Project Name: CORONADO PLACE ADDITION

**CITY OF ALBUQUERQUE
PLANNING DEPARTMENT
July 18, 2007
DRB Comments**

RE: Lots 20 & 21, Coronado Place Addition/minor plat

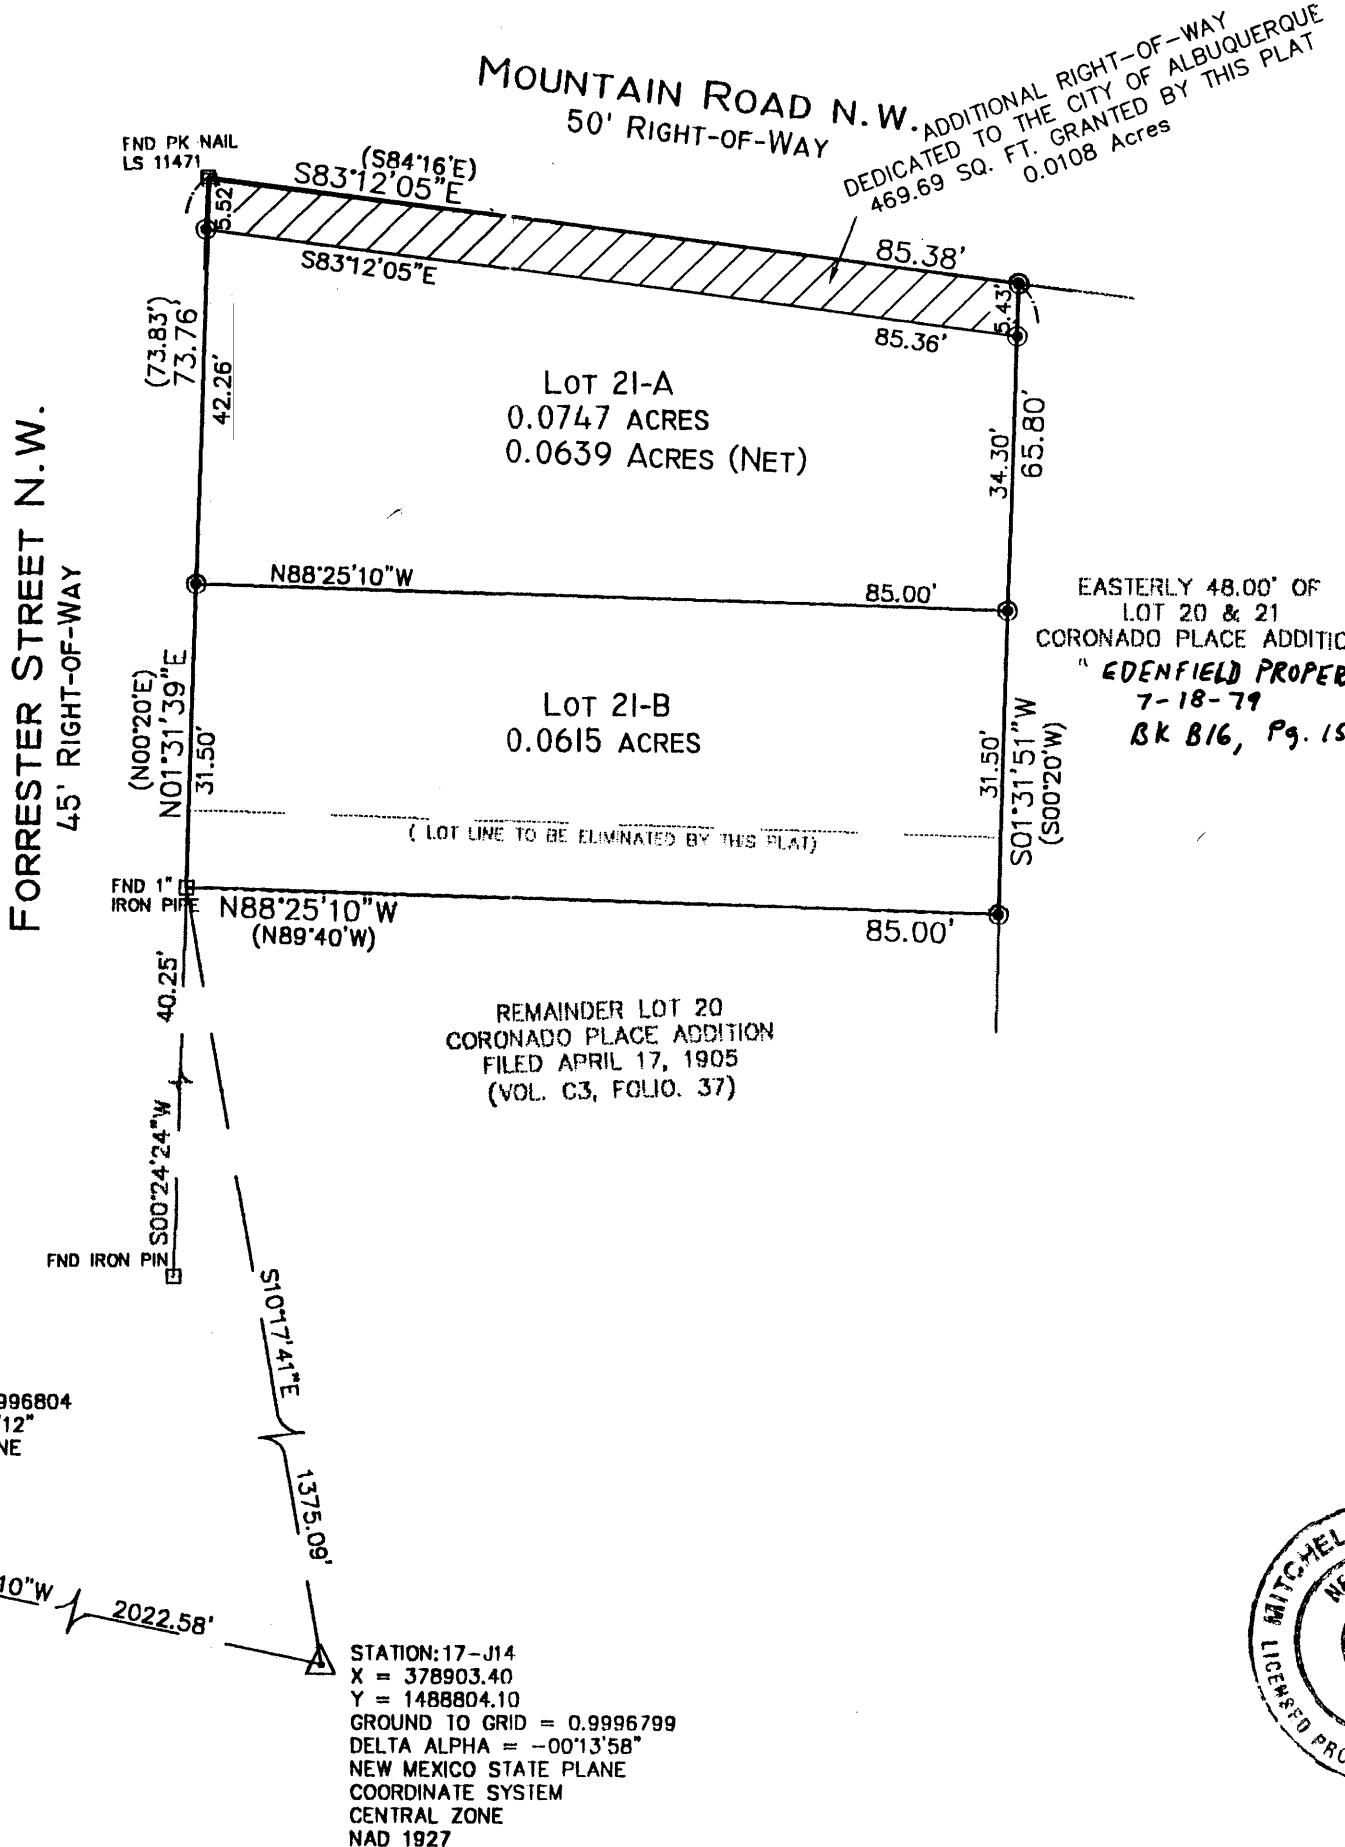
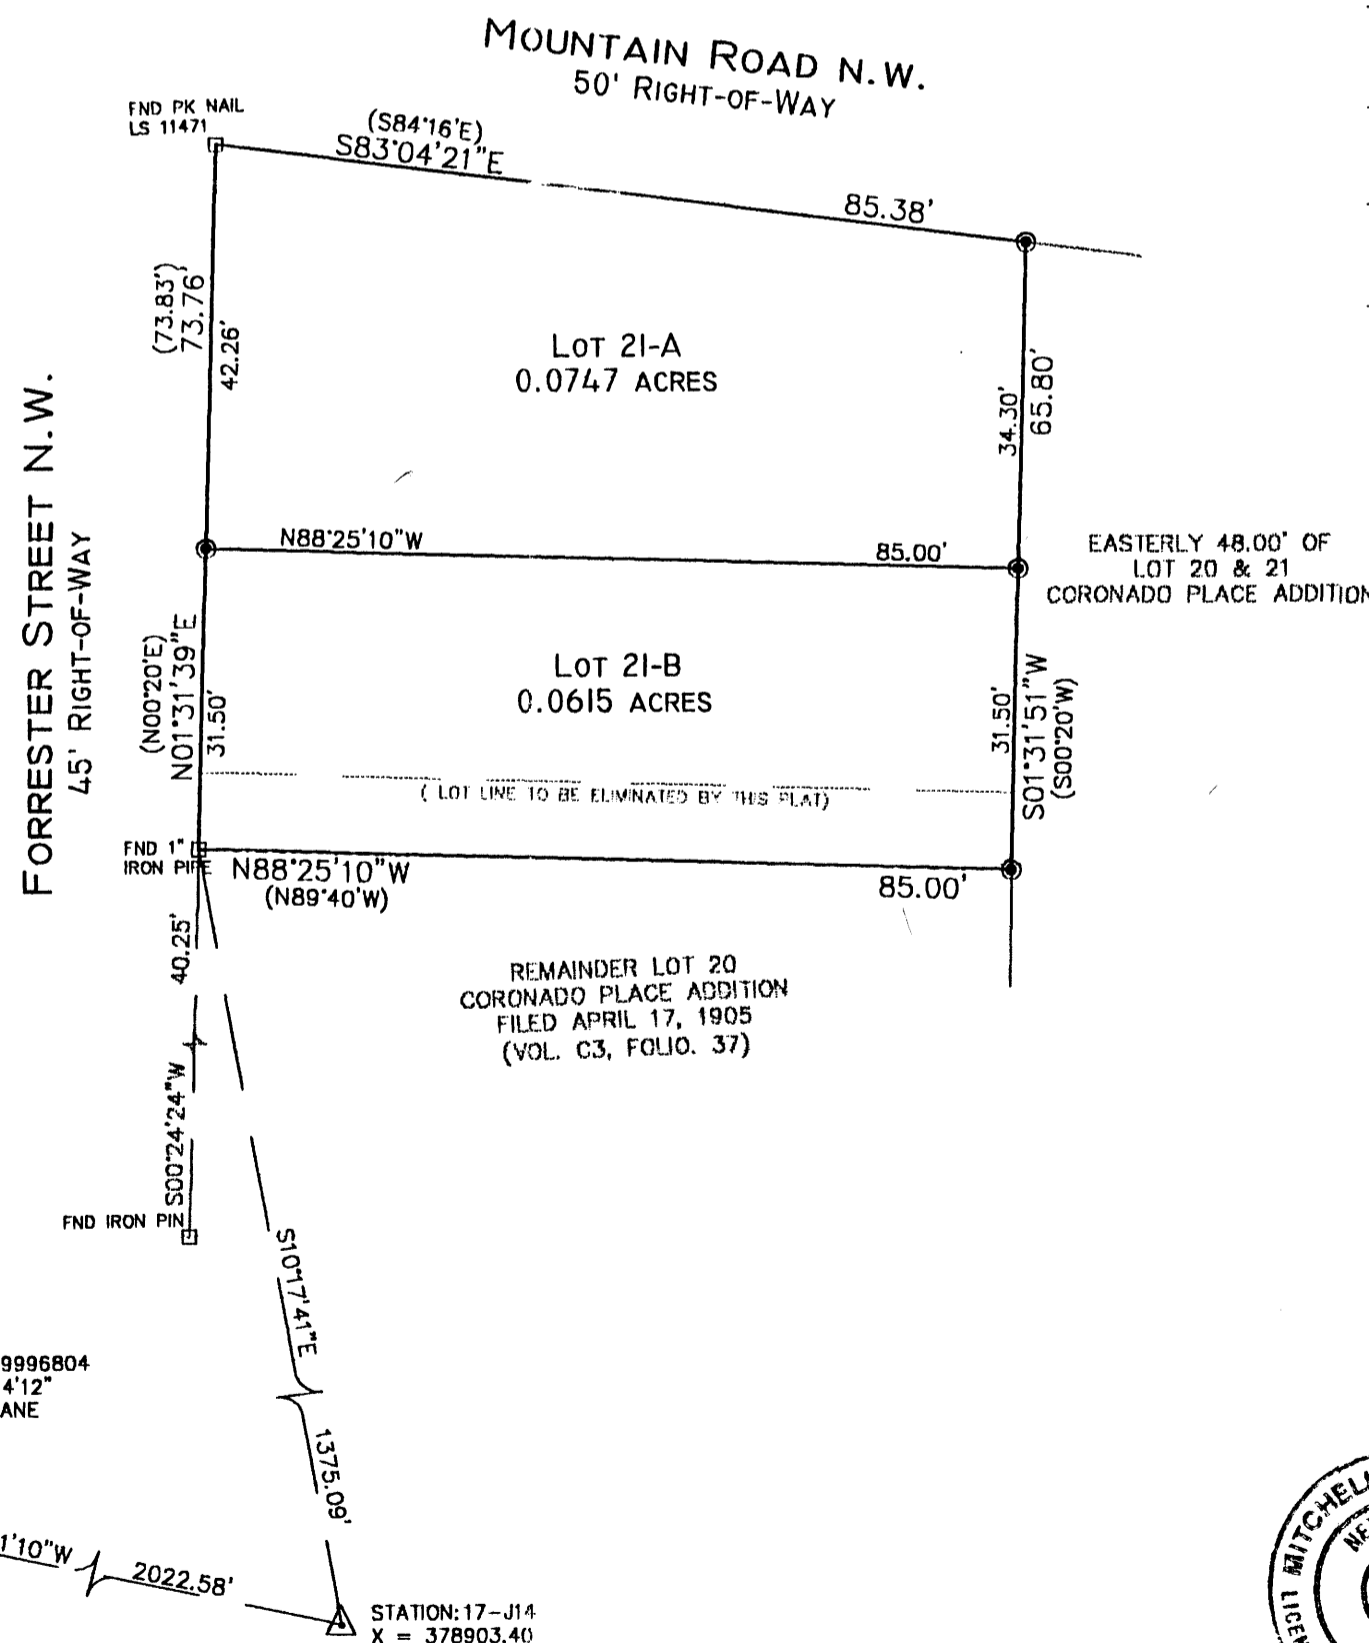
Planning requested supporting documents from the agent justifying the proposed lot alignment. There is a 1905 plat involved as well as other paper documents. The ownership doesn't line up with the lot lines as shown in AGIS.

Agent may record the plat if Planning receives a paper copy for the file.
